Subject: FW: WA/21/21/DOC - Wandleys Farm Condition 3 Materials

Subject: WA/21/21/DOC - Wandleys Farm Condition 3 Materials

The above application does not contain any eaves detail as required by the condition. If these are not provided within the next 7 days the application will be determined as submitted.

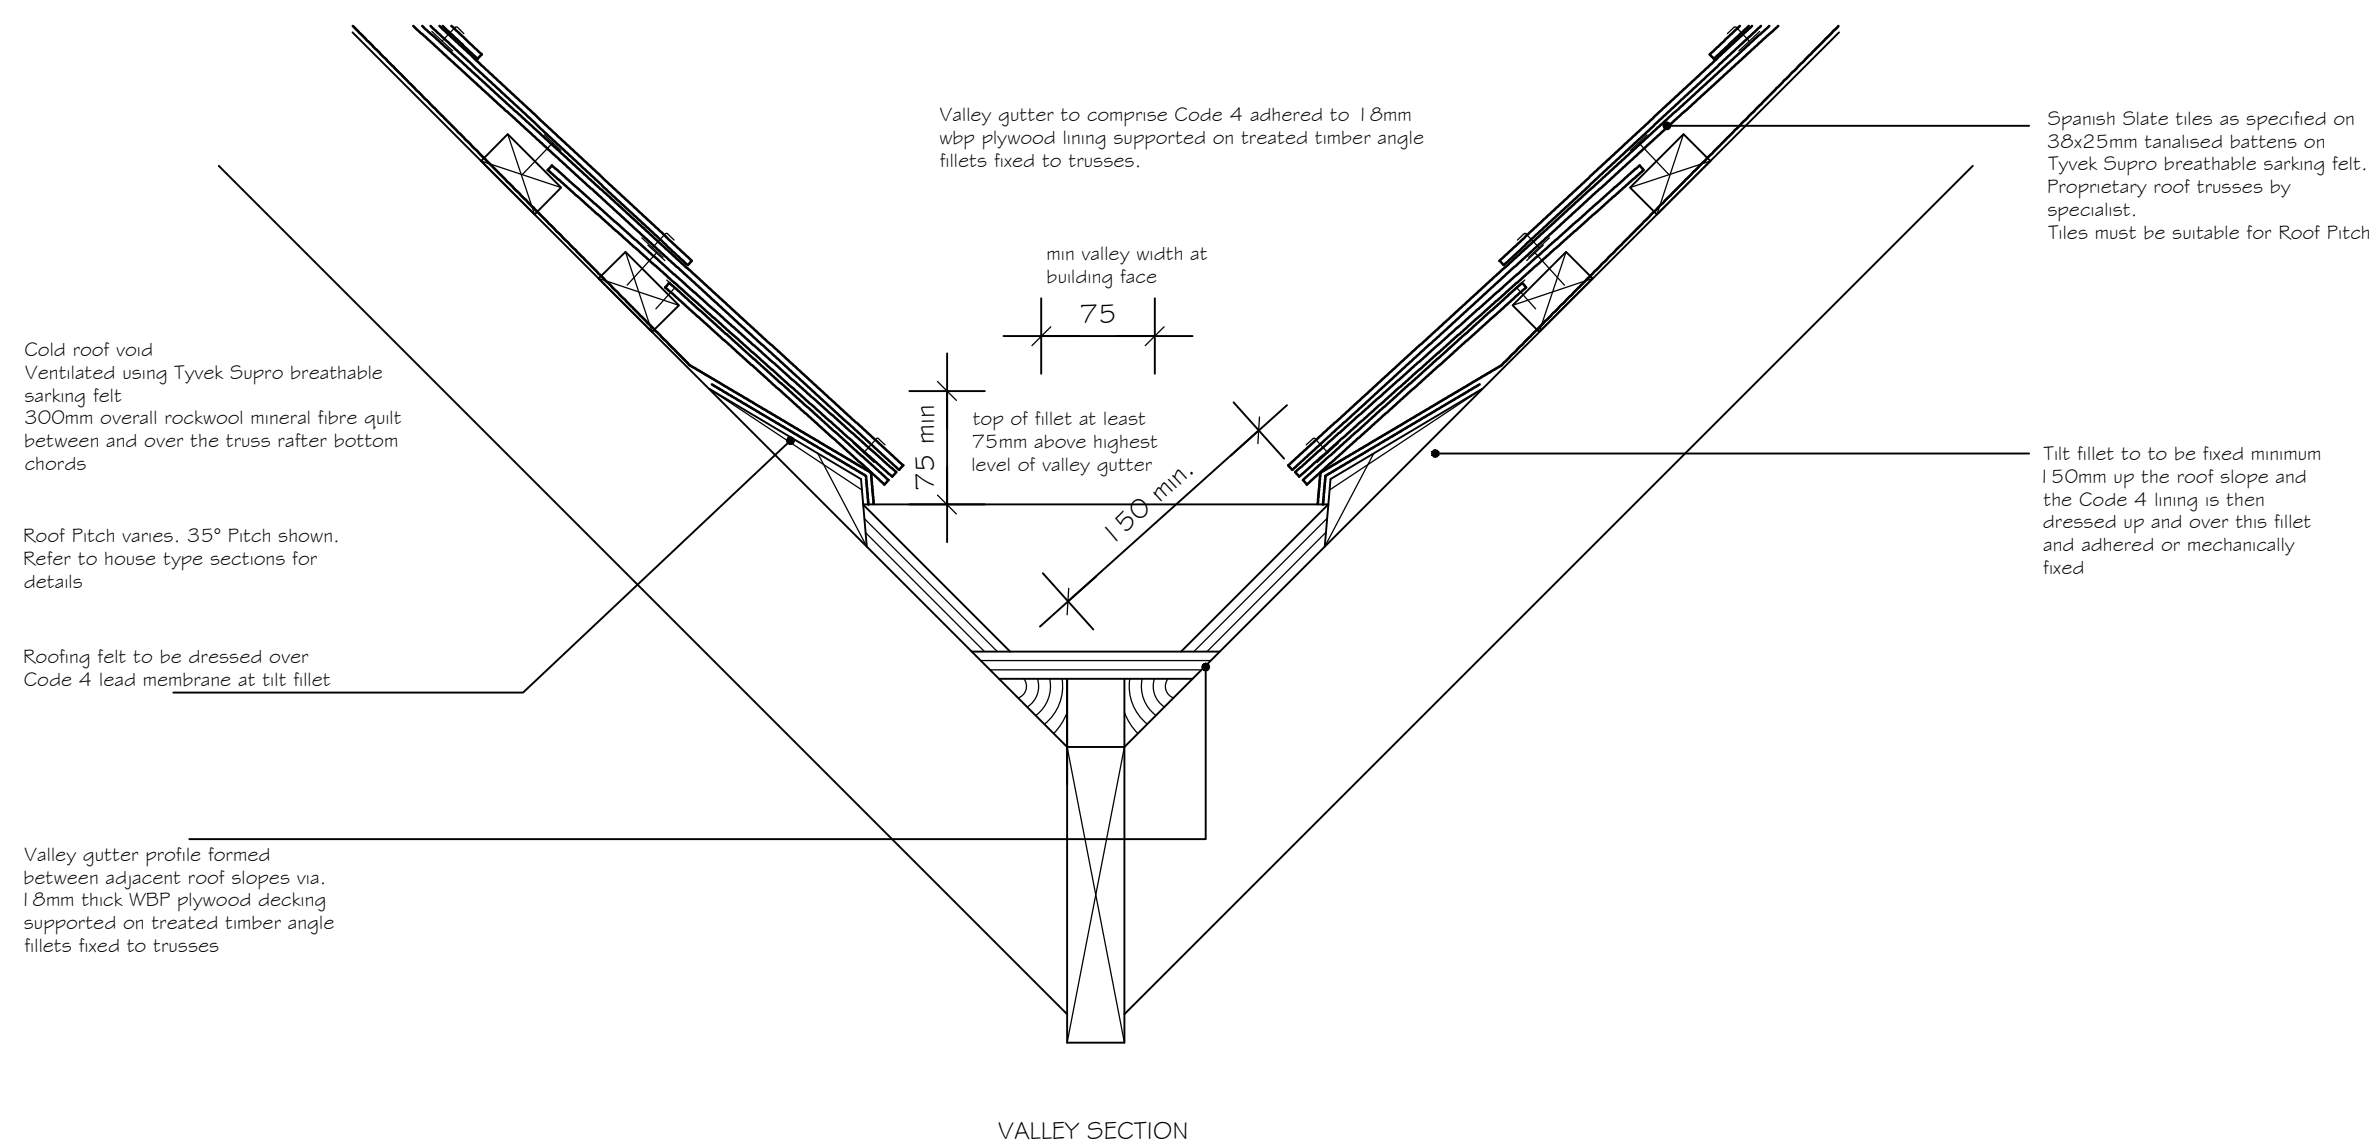
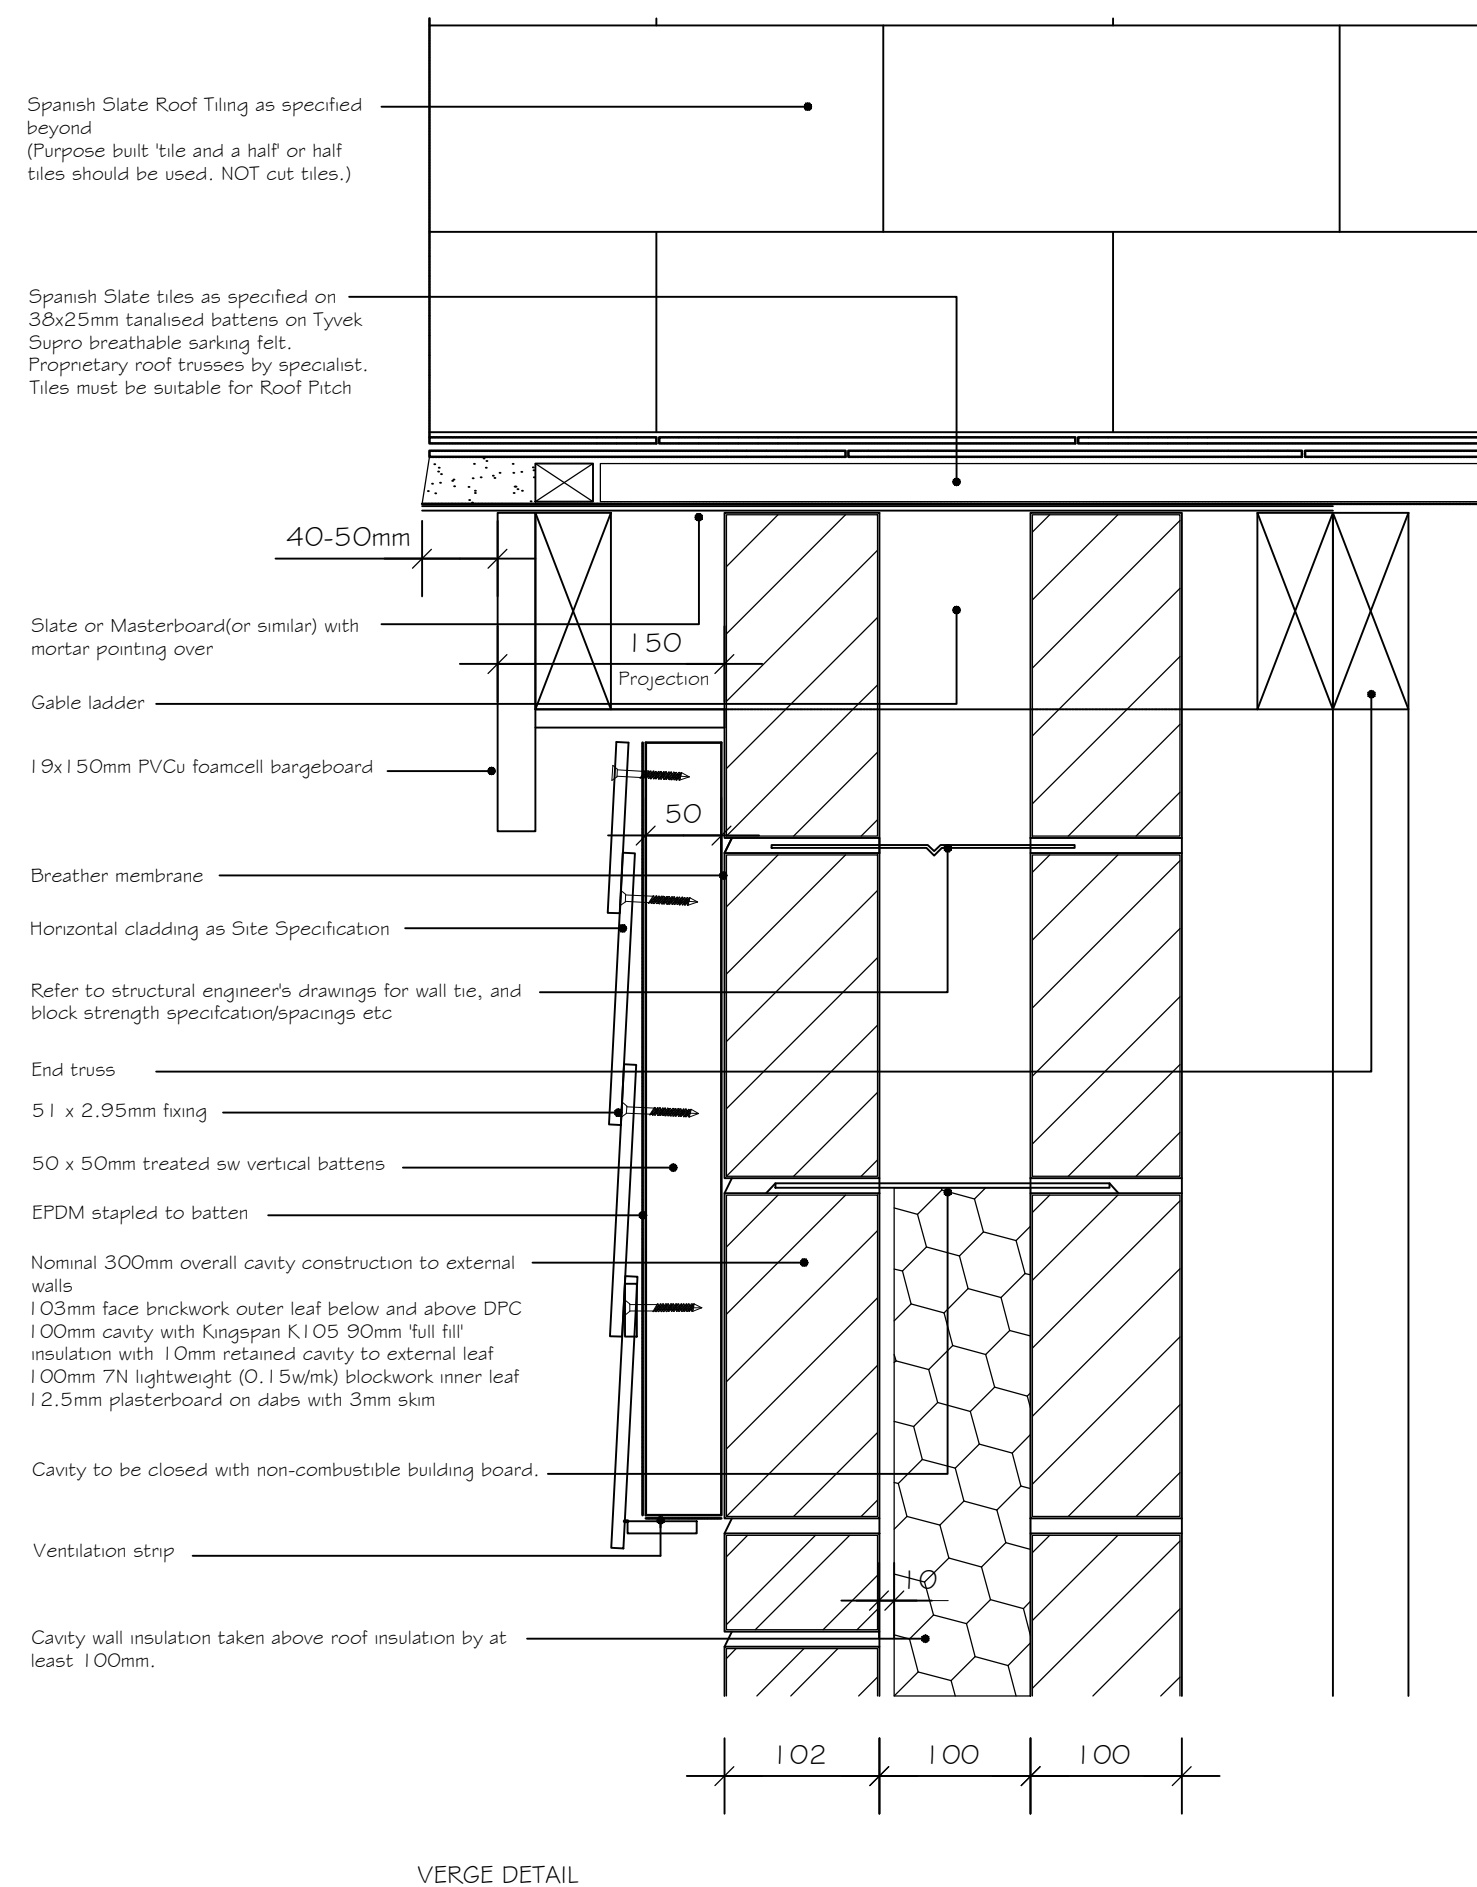
Further the use of white PVCu or powder coated aluminium units to the dwellings is not appropriate in this rural location. Oak effect woodgrain UPVC is suggested as was indicated on the original application. Please can you reconsider the materials for windows and doors of all units. In addition I note that no details of tile hanging for the detached house or materials for the garage have been submitted.
